From: Michael Eastham
Sent: 11 December 2017 12:35
To: Planning.Responses
Subject: FW: Land at Pollards Nursery, Barnham

I have read Noise Assessment for Proposed Residential Development at Lake Lane, Barnham (Report No. JAE9392-REPT1-R5), dated 30 October 2017. Could you ask the applicant to reply to the following points please?

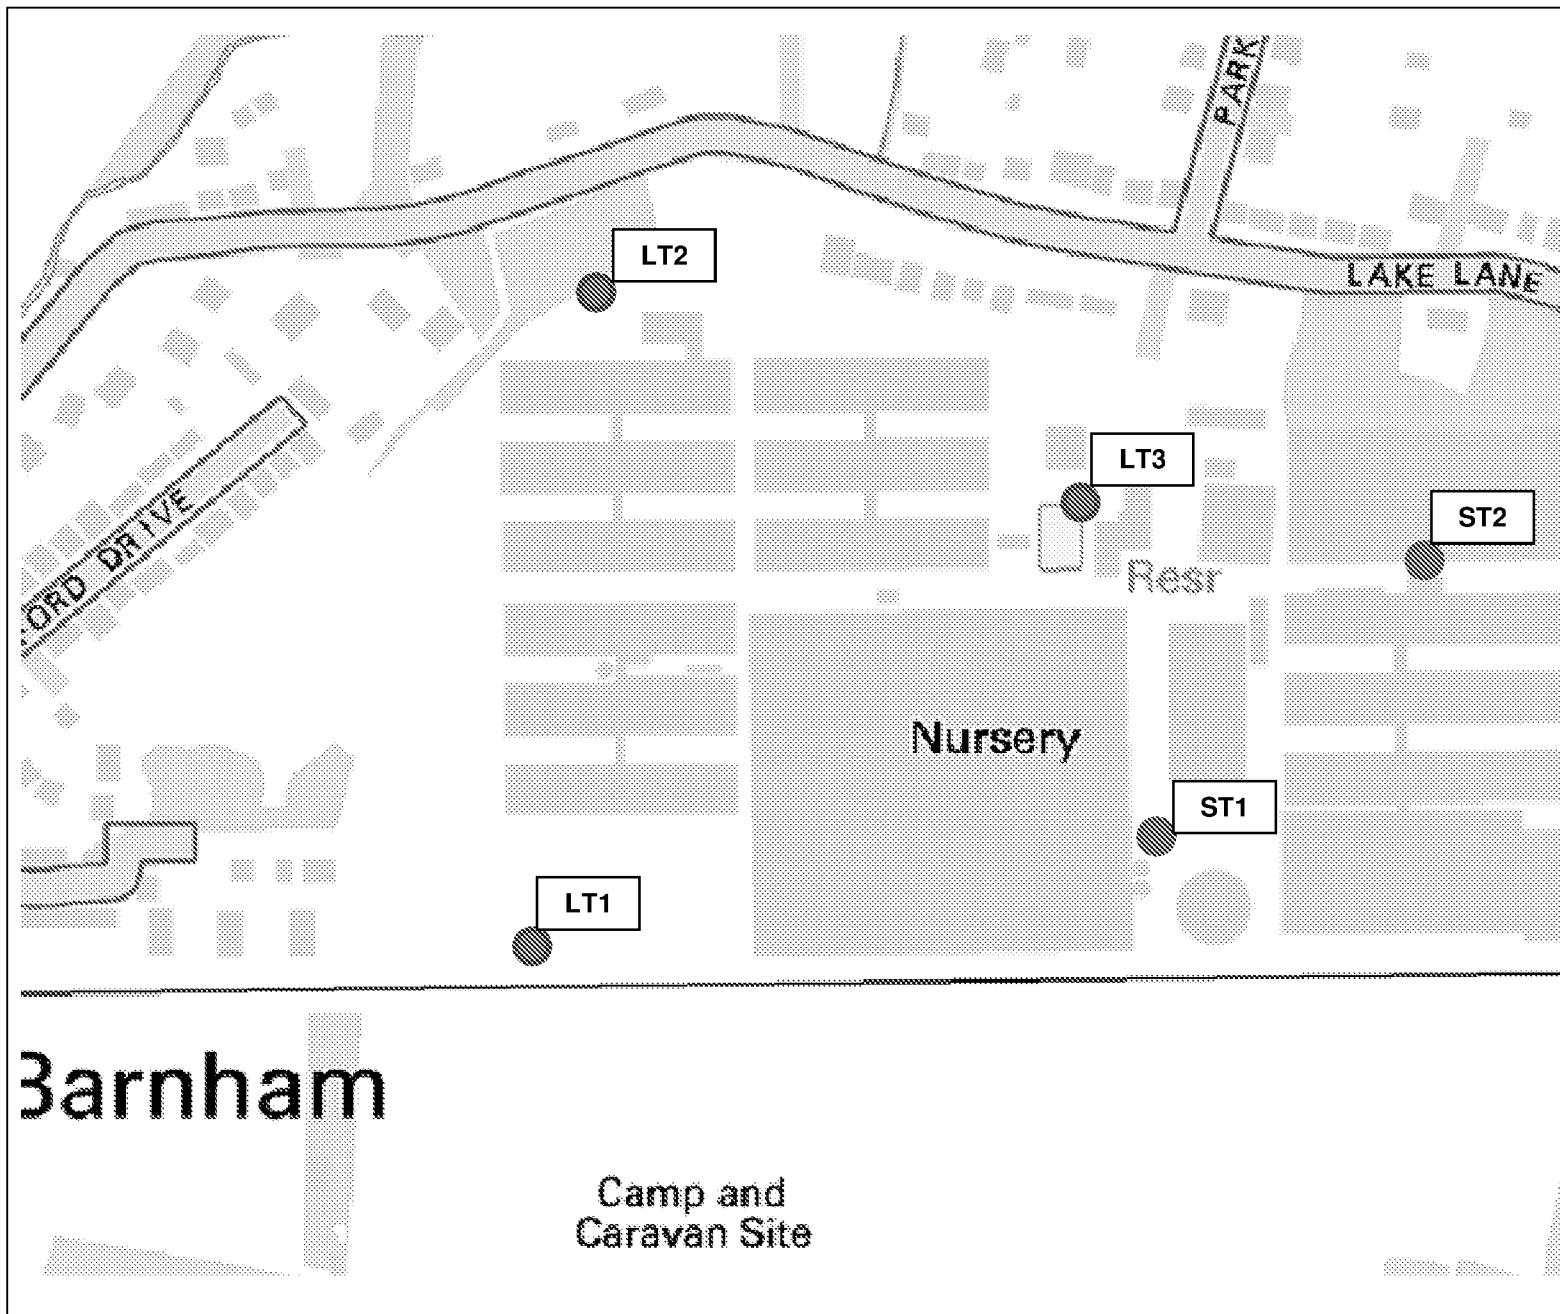
1. Is point LT2 actually on the northern boundary of the site? I am aware that the site layout has changed over time and I'm not sure that I've been looking at the most recent layout.
